07429
20 October 2008

**COCHLEAR GLOBAL HEADQUARTERS - MACQUARIE UNIVERSITY
(MP 08_0032) / RESPONSE TO SUBMISSIONS & PREFERRED PROJECT REPORT**

This has resulted in minor revisions to the landscape layout as shown in the appended plan by DEM – Stage 1 Overall Landscape Plan Drawing No. LA – 0501 Revision a08 (dated 7 October 2008).

**Stage 1
overall landscape plan**

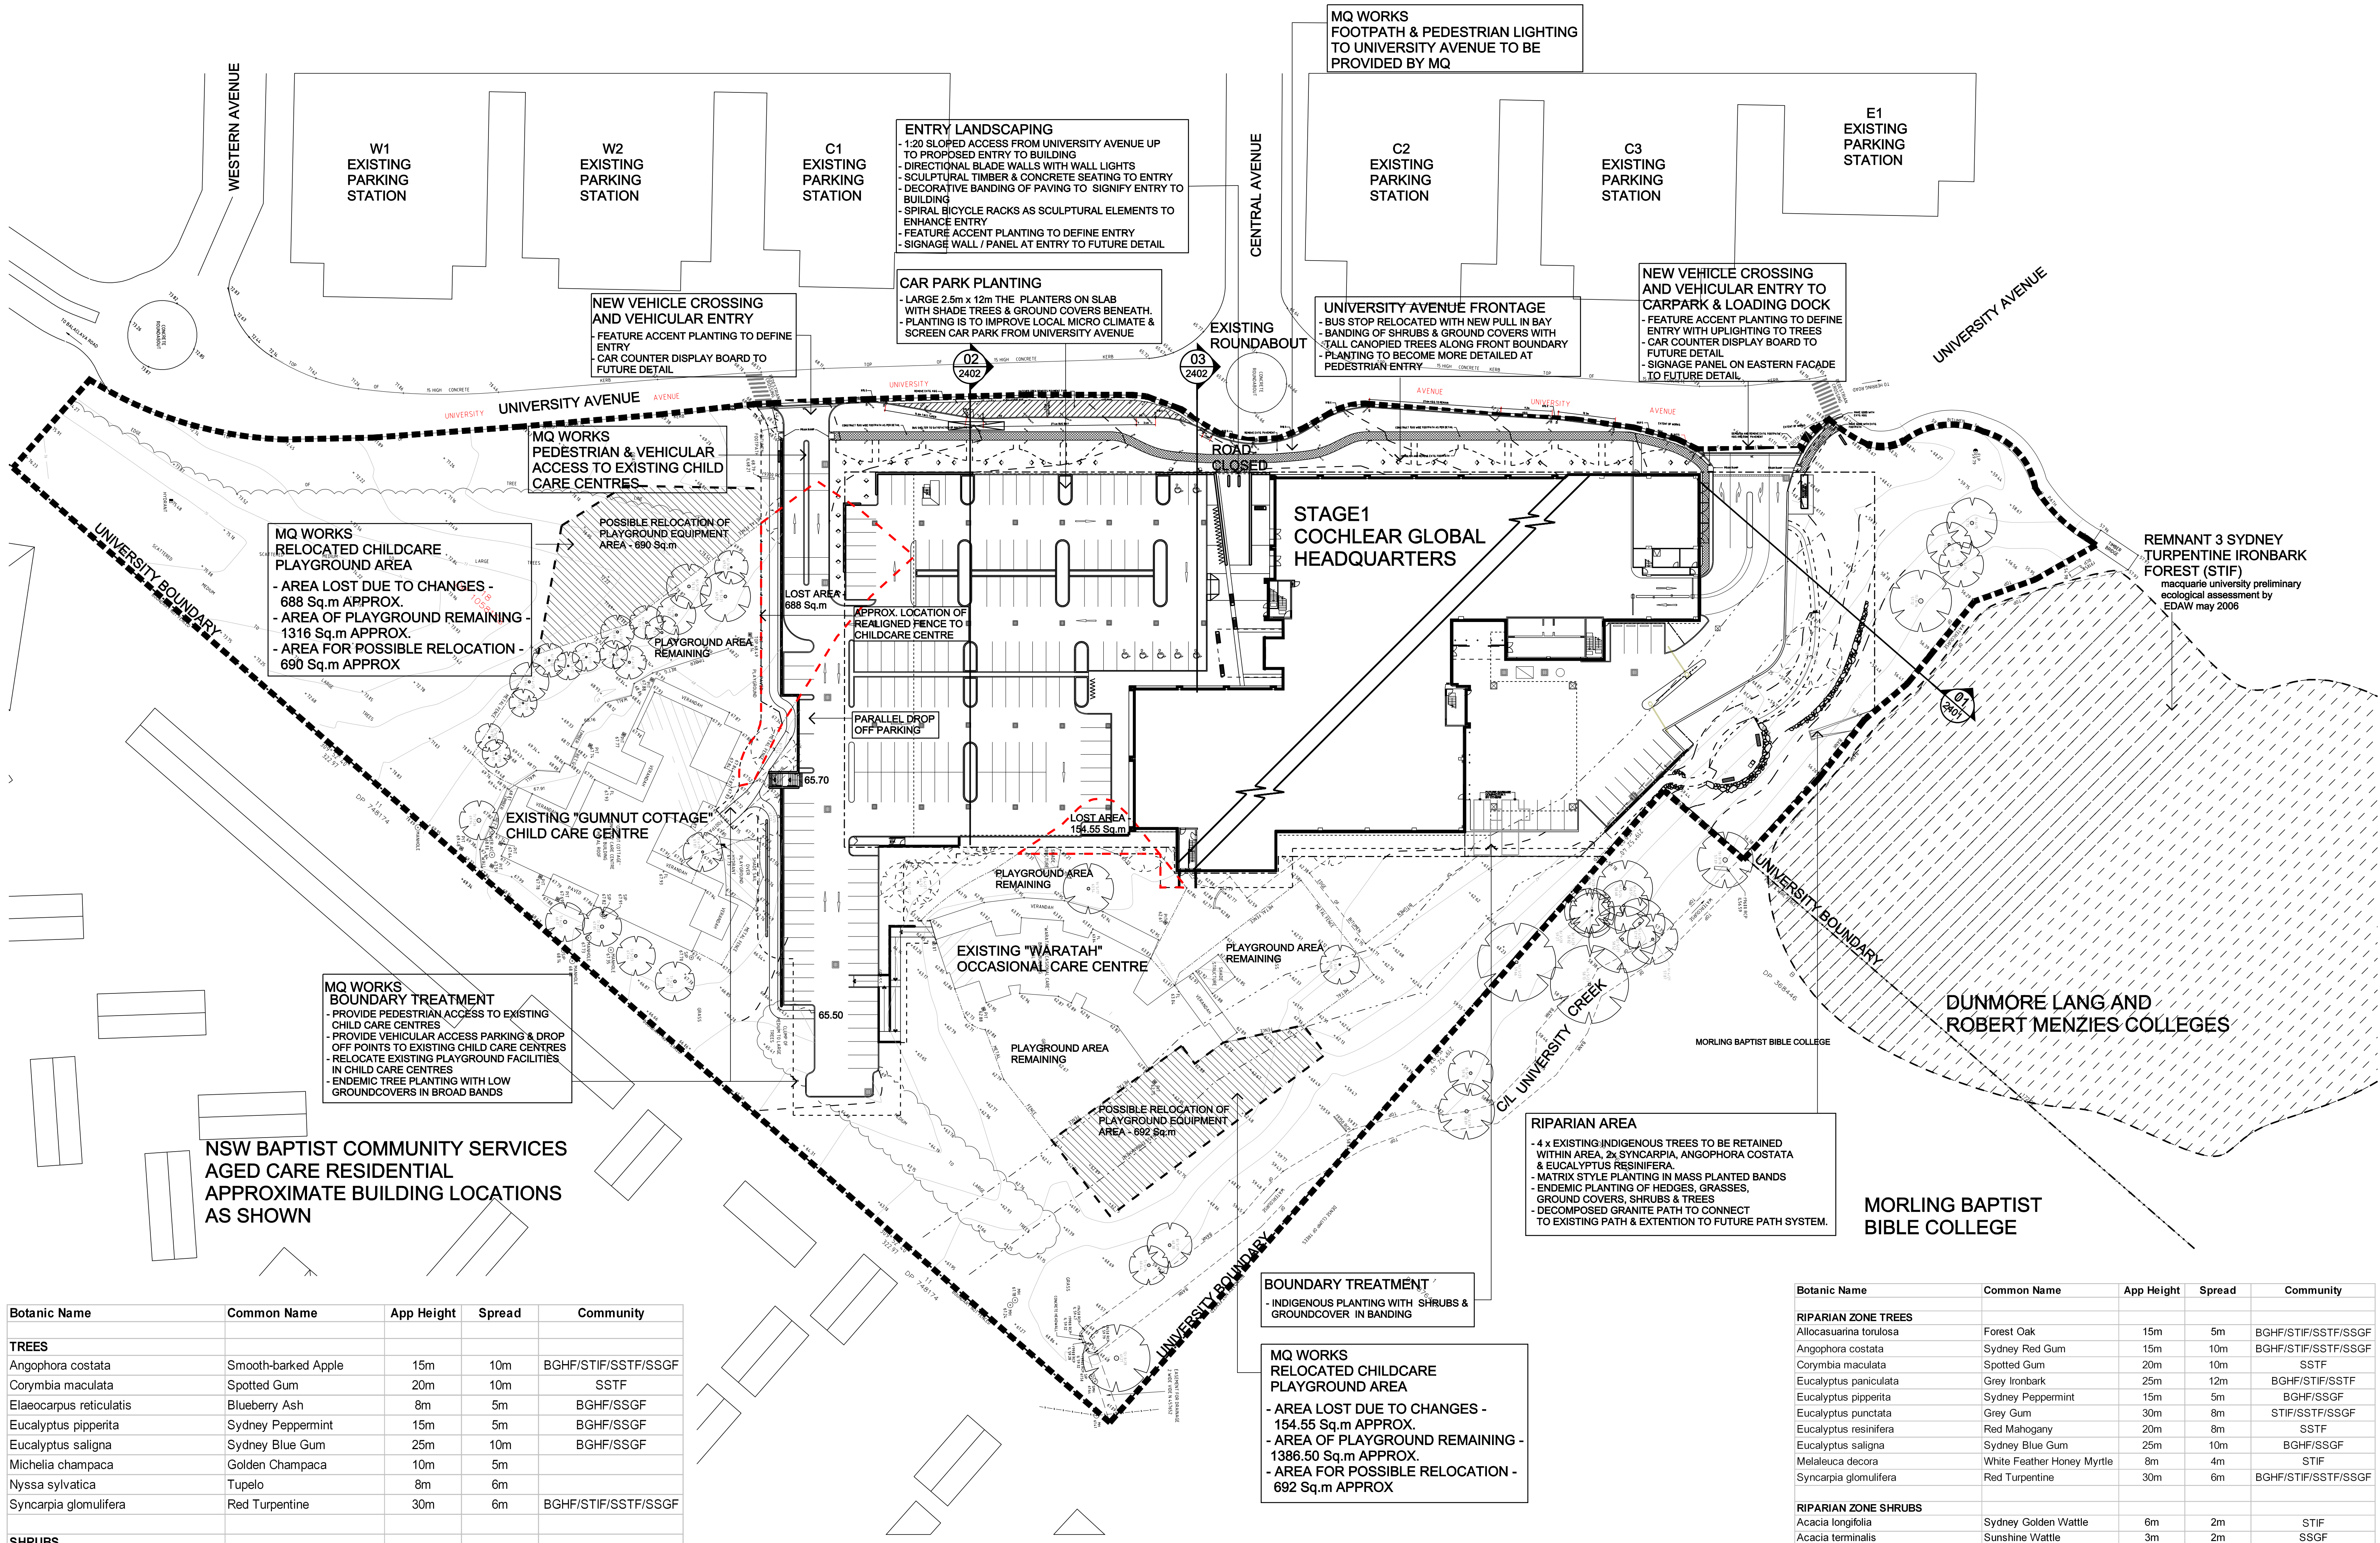
Since the submission of the Project Application, ongoing refinement of the development has taken place as a result of issues raised concerning the ongoing operation of both the "Gumnut Cottage" and "Waratah" child care centres.

It is proposed to reconfigure the vehicular and pedestrian access to the western edge of the development site to improve access to the centres, in particular parallel drop-off areas and at-grade pedestrian, pram and shared access. Further, areas of playgrounds lost to the development have been relocated elsewhere within the development site. The "Gumnut Cottage" centre has gained a relocated portion of playground with an area of 690m² (the lost area being 688m²) whilst the "Waratah" centre has gained a new extended playground of 692m² (the lost area being about 155m²).
